From: Paul Cann <Paul.Cann@arun.gov.uk>
Sent: Wednesday, May 24, 2023 3:13 PM
To: Planning.Responses <Planning.Responses@arun.gov.uk>
Cc: Karl McLaughlin <Karl.McLaughlin@arun.gov.uk>
Subject: RE: Planning Consultation on: P/88/22/DOC

Application No: P/88/22/DOC
Registered: 24th May 2022
Site Address: Land North of Sefter Road & 80 Rose Green Road Pagham
Description of Works: Approval of details reserved by condition imposed under P/134/16/OUT relating to conditions 10-surface water drainage, 12-maintenance and management of surface water drainage system, 14-foul drainage system, 16-external lighting, 17-Construction Management Plan, 22-setting out when roads, footpaths, cycleways and emergency routes are to be construction, 26-street lighting and 28 (part)-energy conservation and renewable energy.

North of Sefter Road, Pagham – P/88/22/DOC Comments Tracker				Initial Issue Date: 12-10-2022 Issue Date: - Revision 1.2	
	ADC Drainage Comments 11-10-22	Applicants Response	ADC Drainage Comments 18-11-22	Applicants Response	ADC Drainage Comments 25-01-23
I hereby confirm the surface water drainage design and maintenance manual is satisfactory and recommend discharge of conditions 10 &

Drawing Number	Rev.
10768/1810	P8

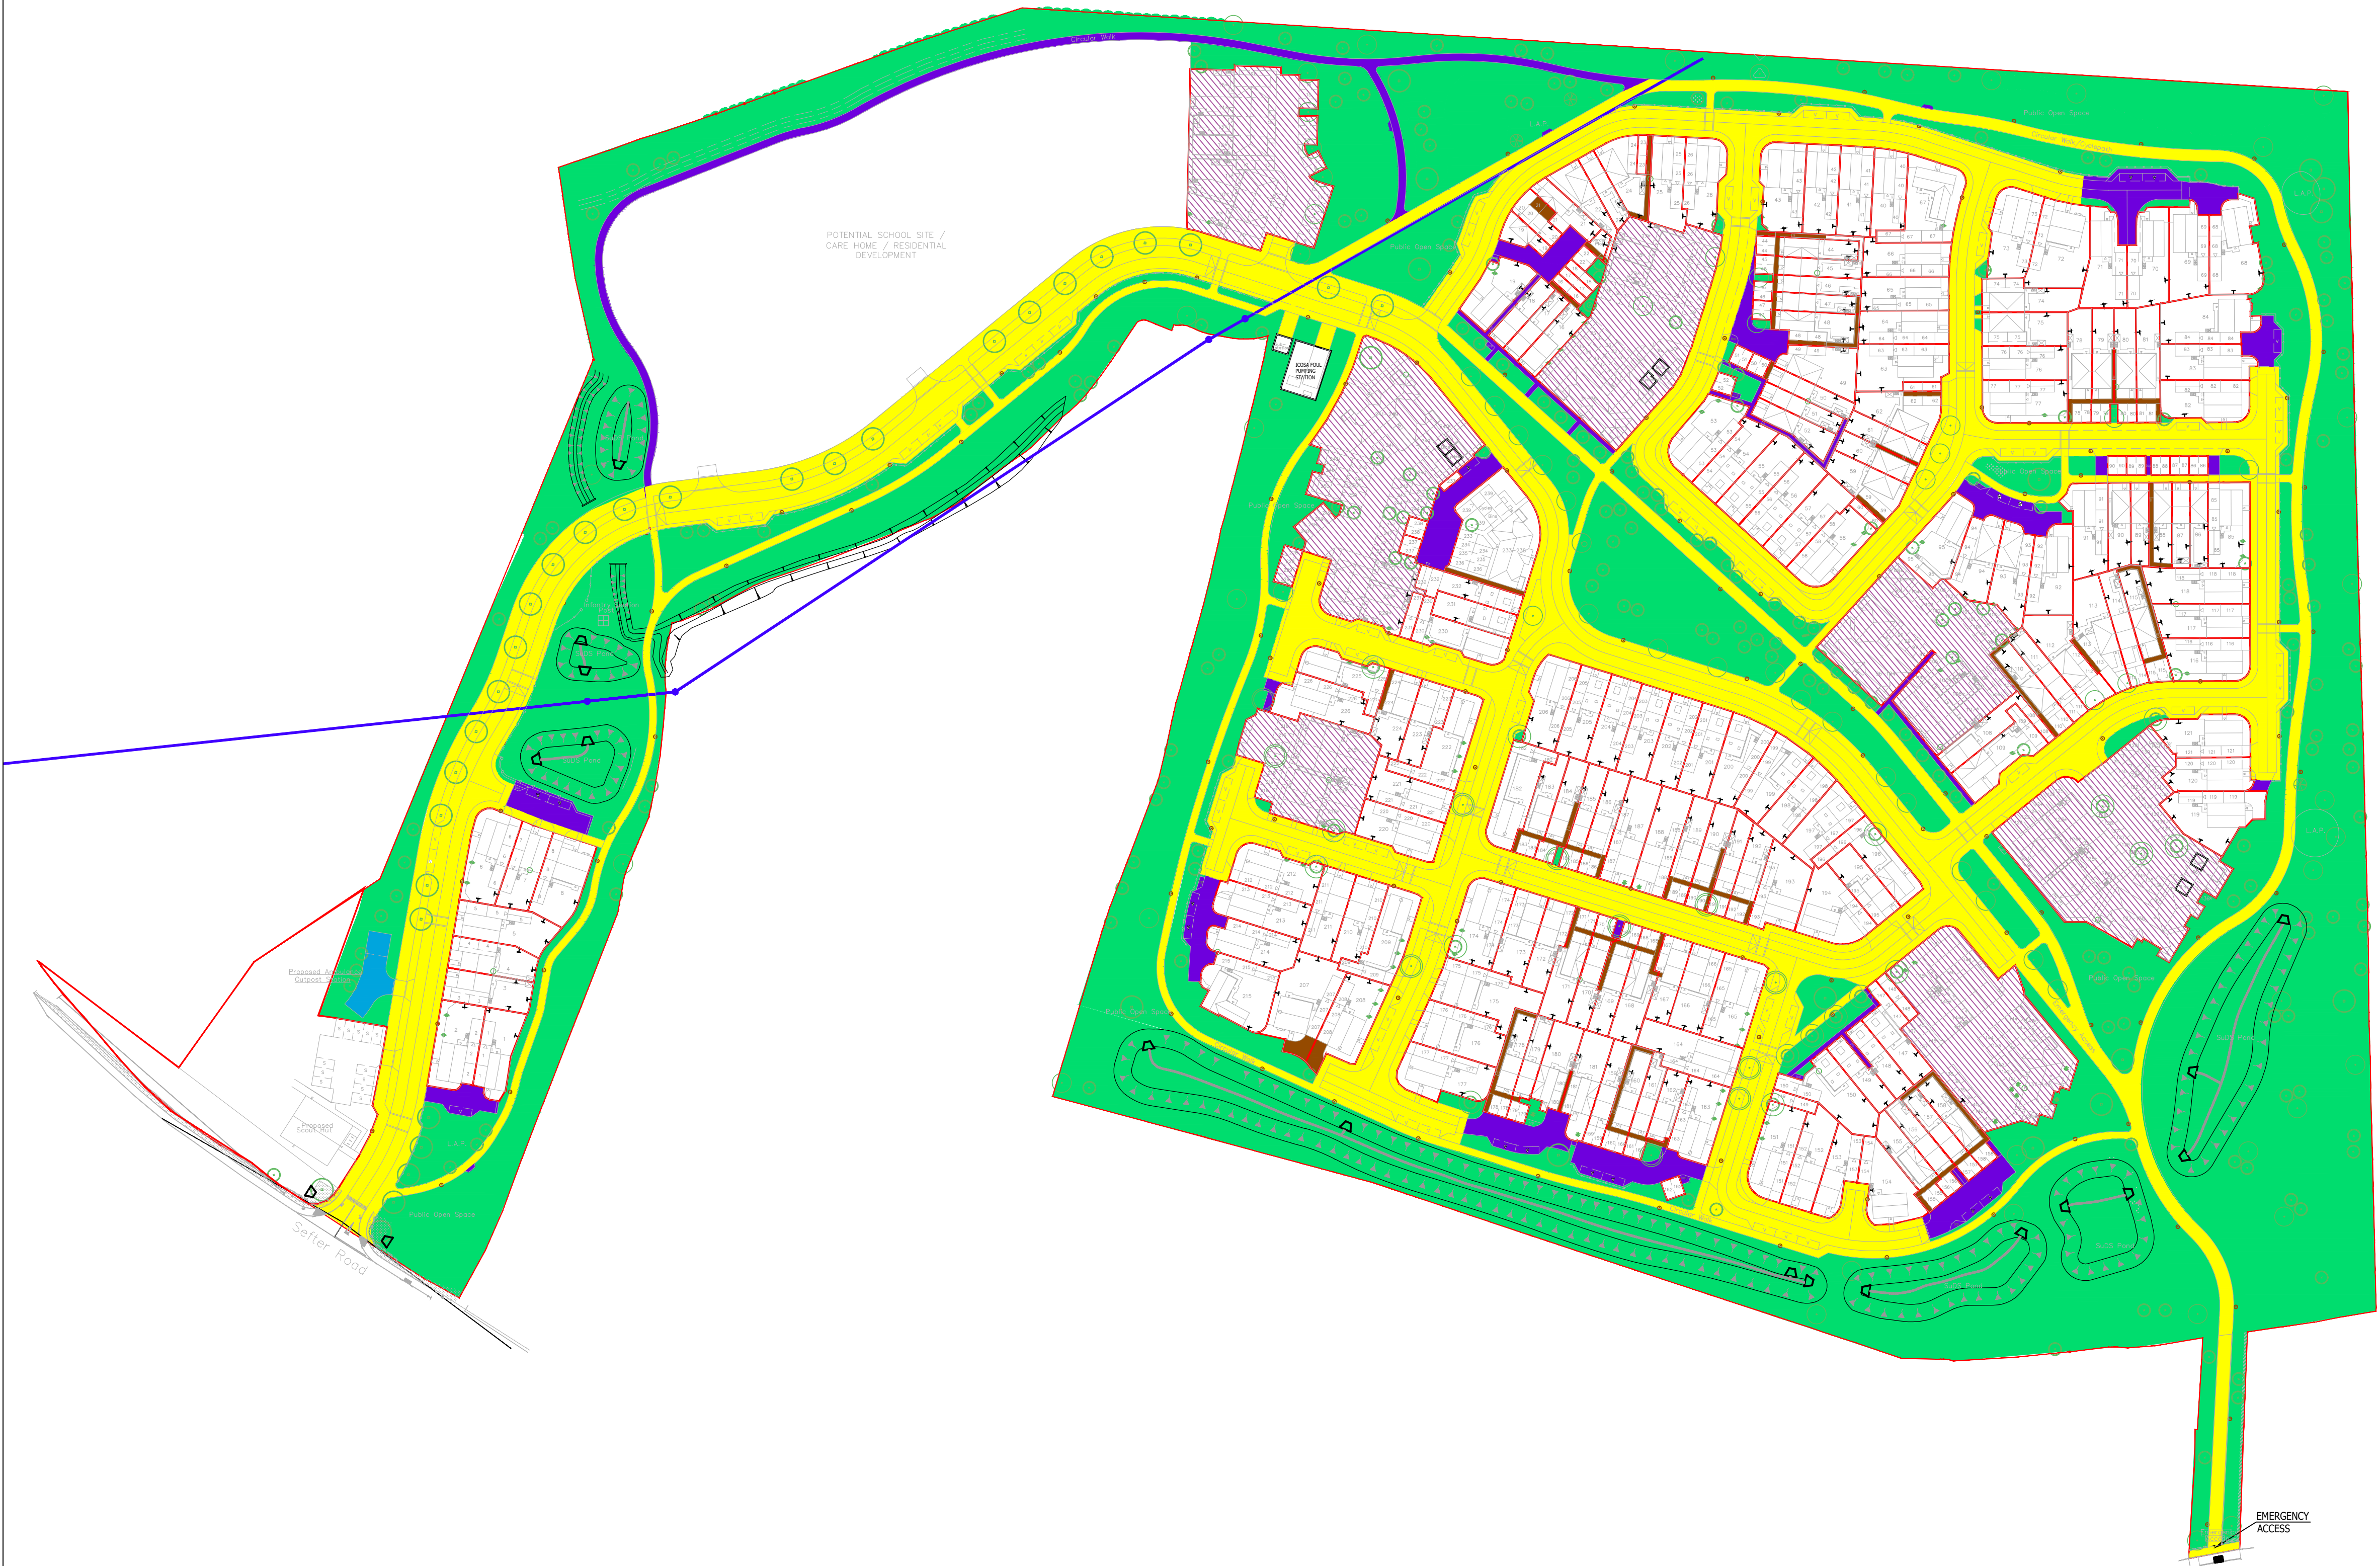
39.	Please advise if ICOSA are adopting the SW basins and if these comply with their design criteria/policy, in addition to DCG.	Icosa Water will not adopt attenuation ponds	Noted, with reference to conveyance drawing 1810 these area re to be 'privately managed land'. Please provide details of the management company arrangement in due course.	To follow	Noted to follow.

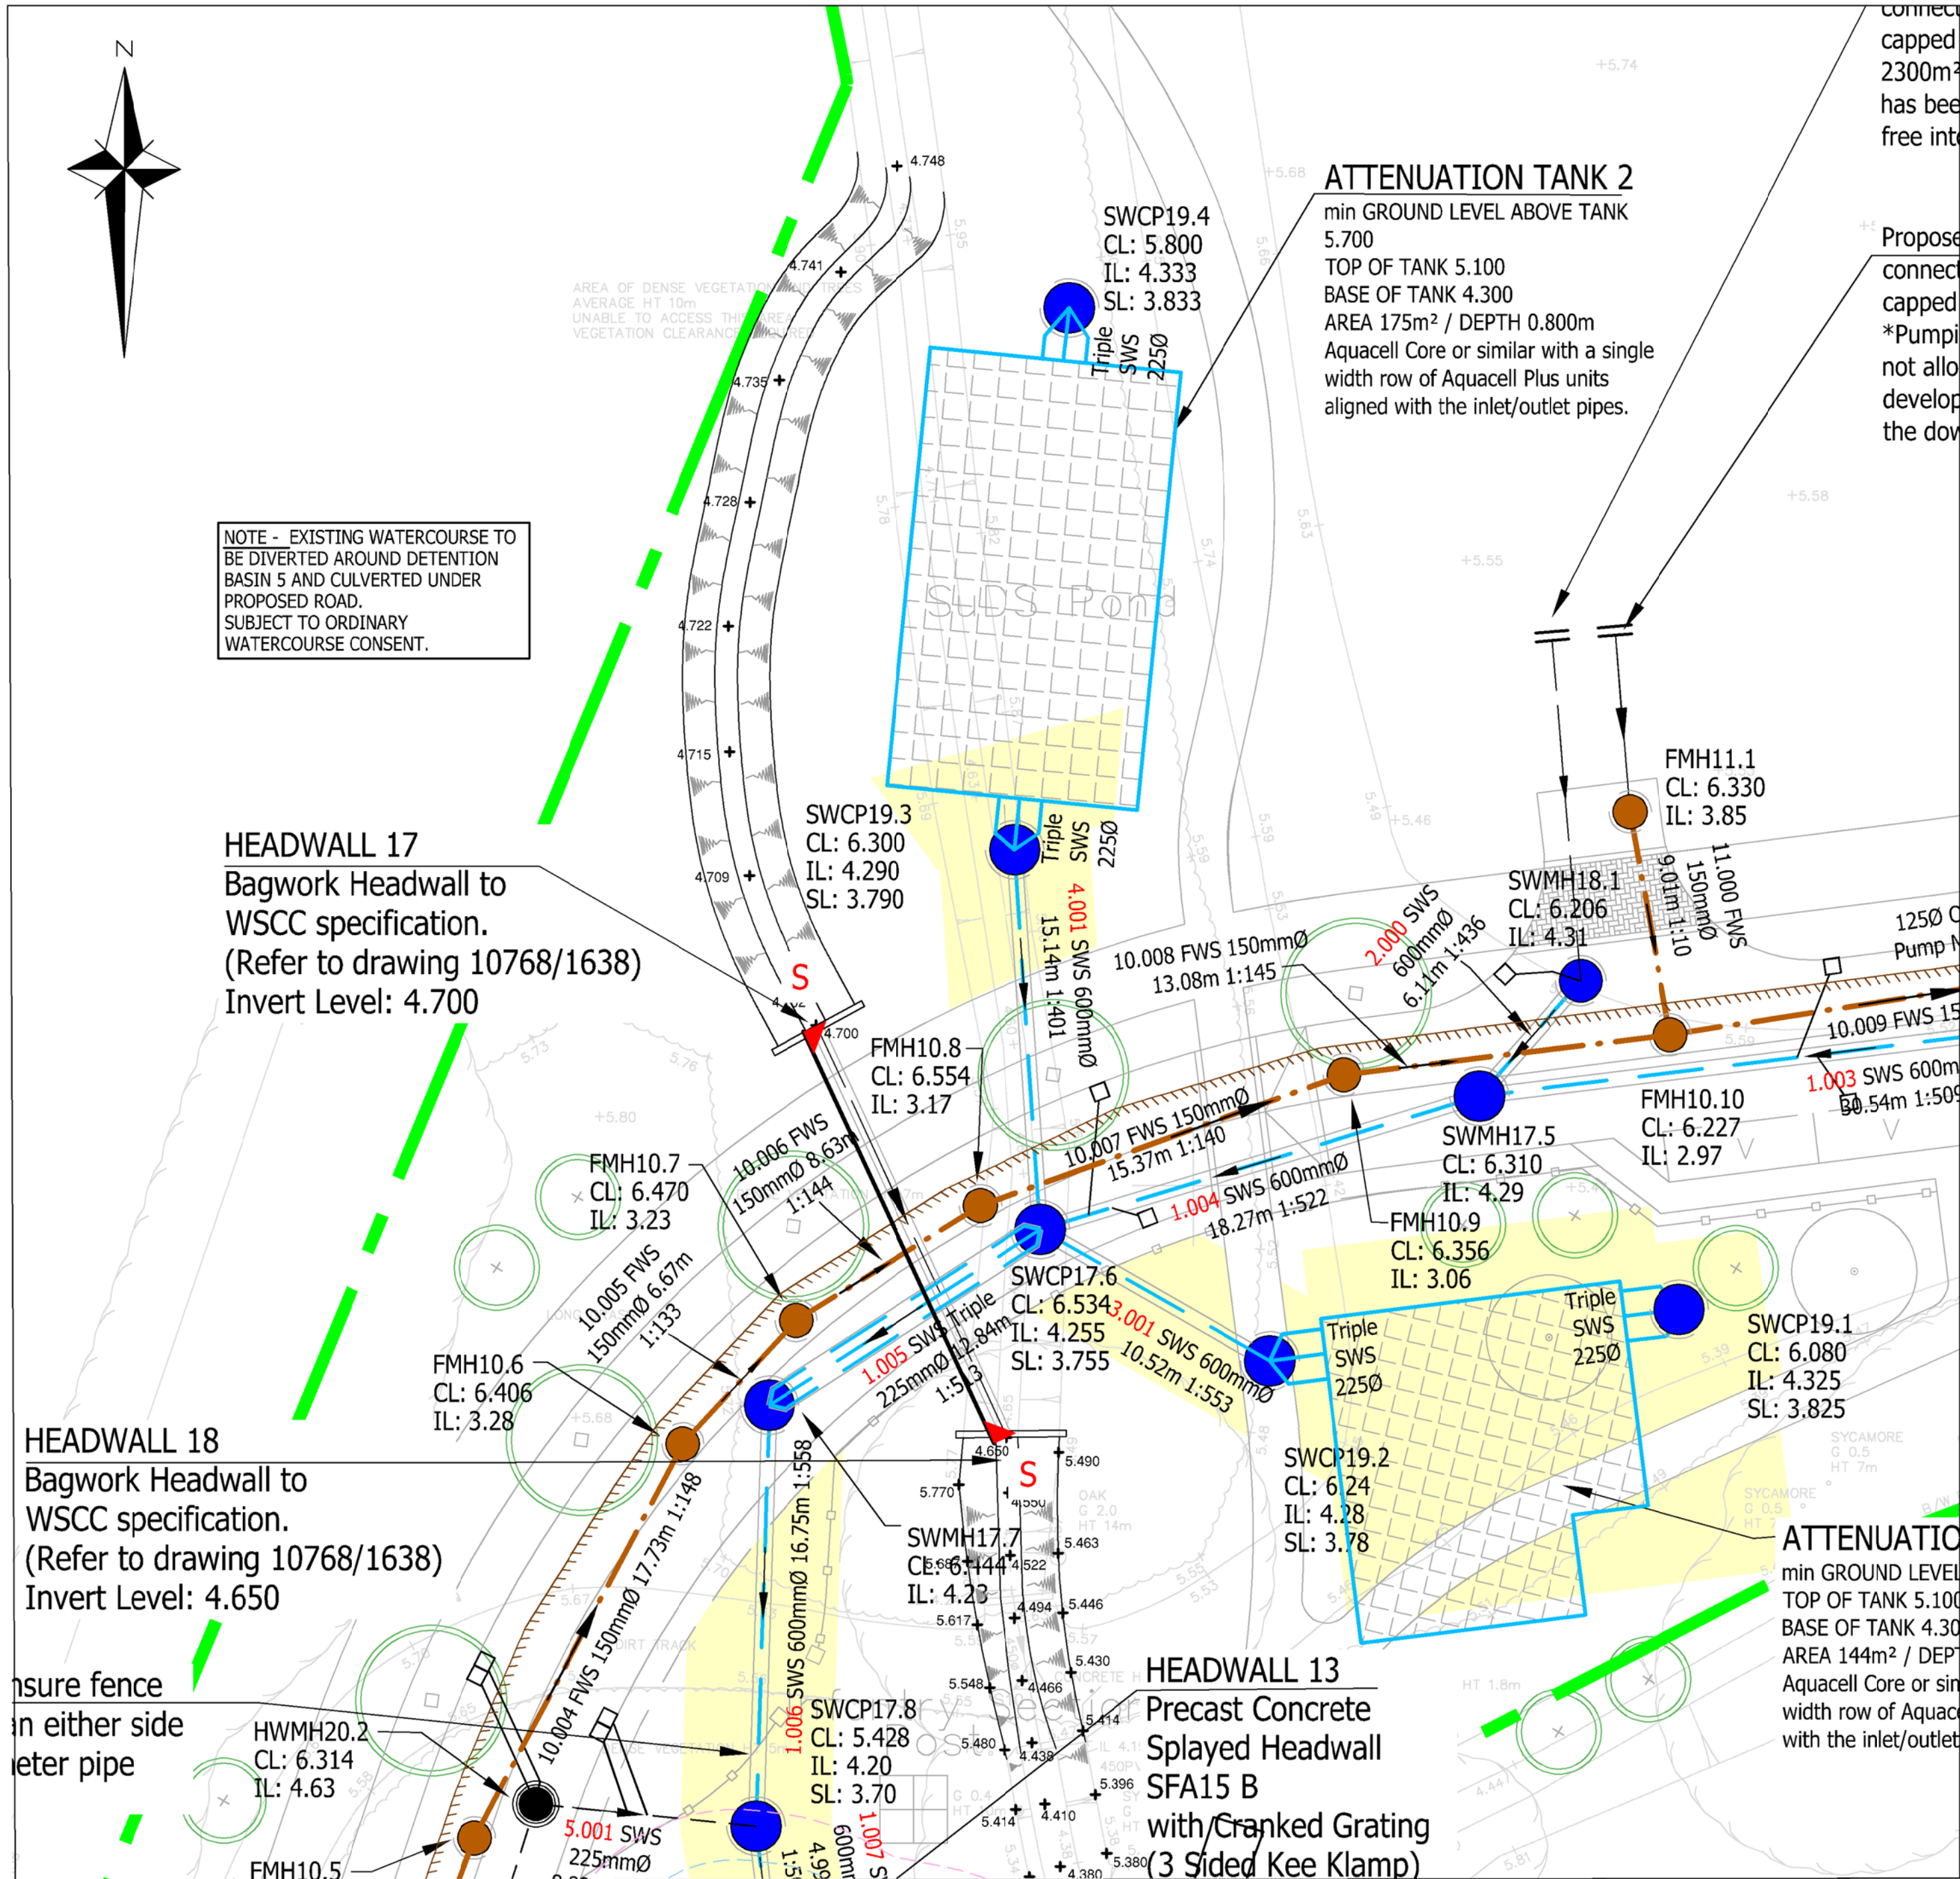
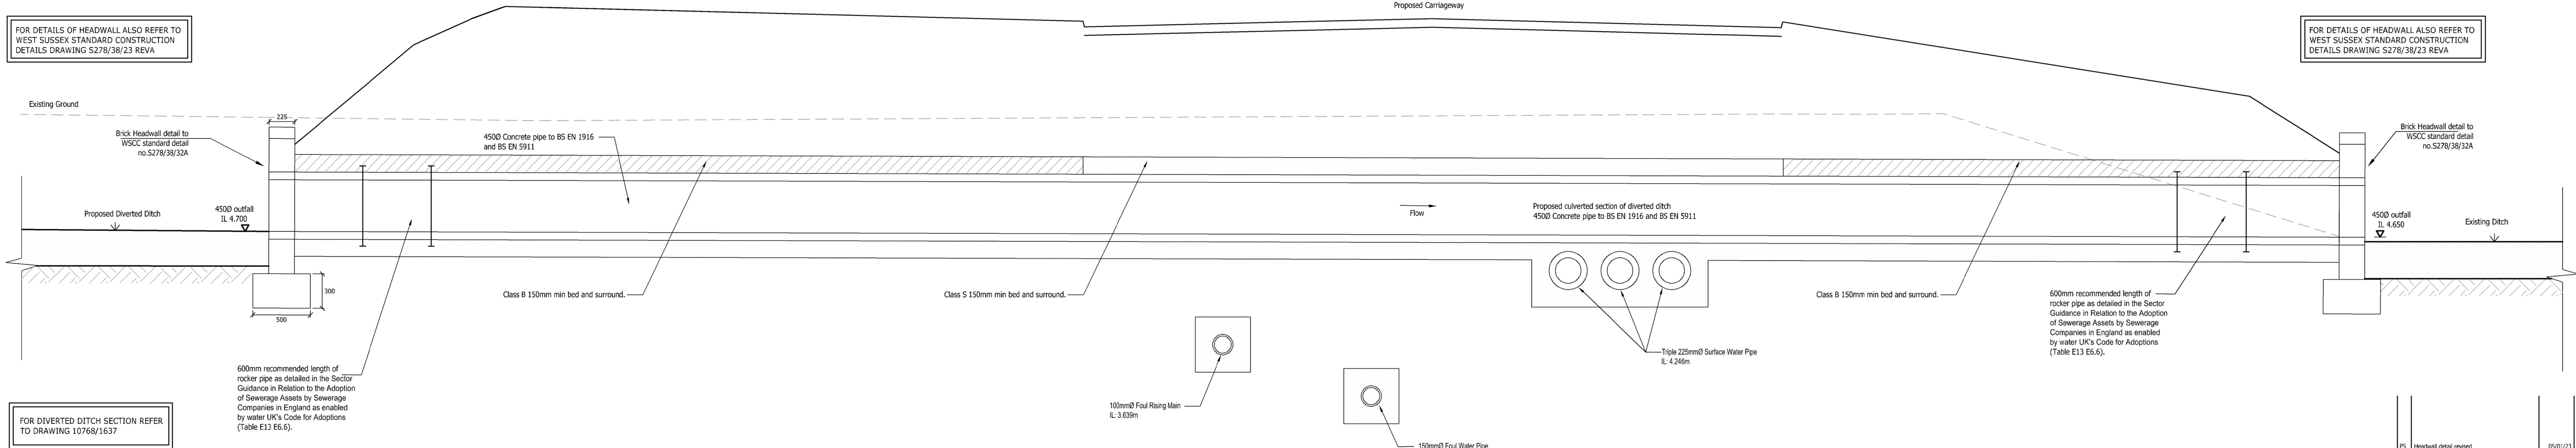
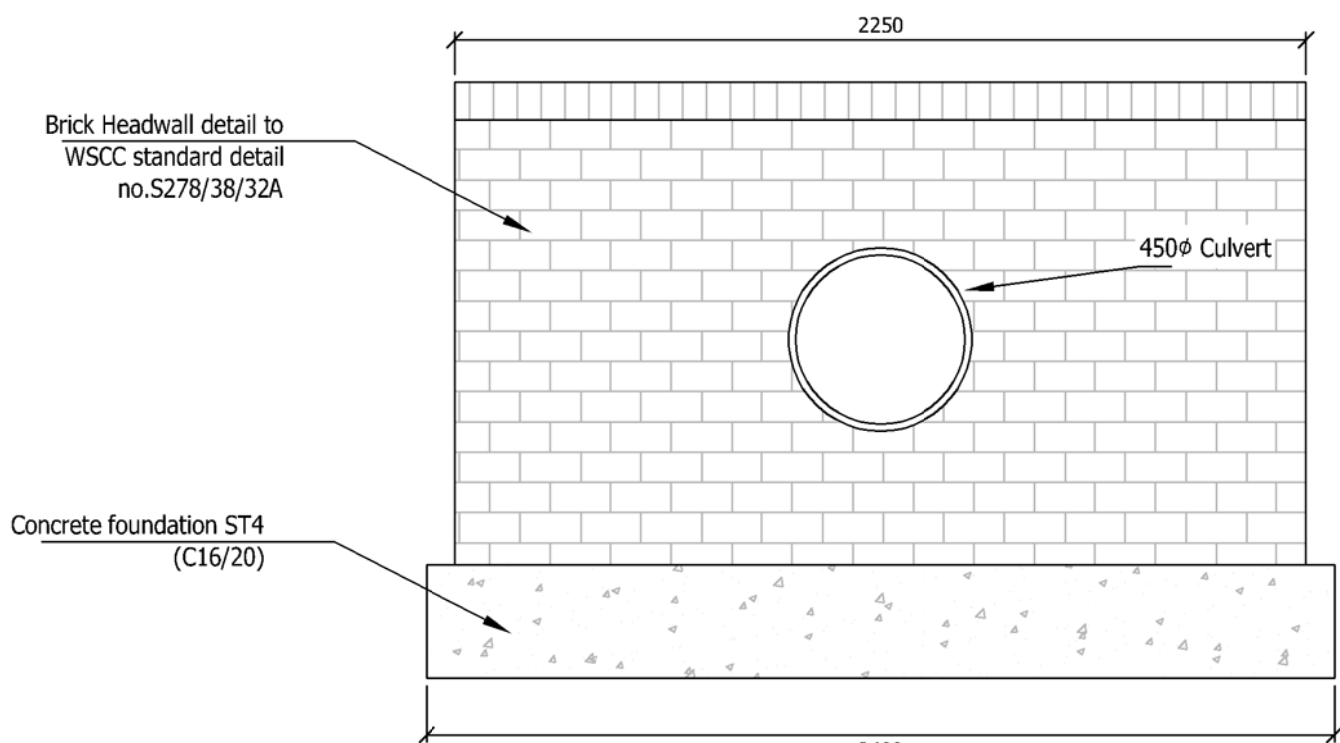
18.	Drawing 1620 to be updated to highlight flow control manholes.	10768/1620 schedules updated.	Agreed and closed.	-	
19.	Headwall schedule to be provided.	Headwall schedule added on drawing 10768/1502	Headwall 17 & 18 do not comply with WSCC S278/38 standards. Bagwork headwalls are only intended for gullies. These headwalls shall comply with WSCC detail 32 (dictated by pipe size).	Noted. The Table on Drg 1502 & The section on drawing 1638 now shows headwalls as per WSCC Detail no.32.	Noted and Closed.
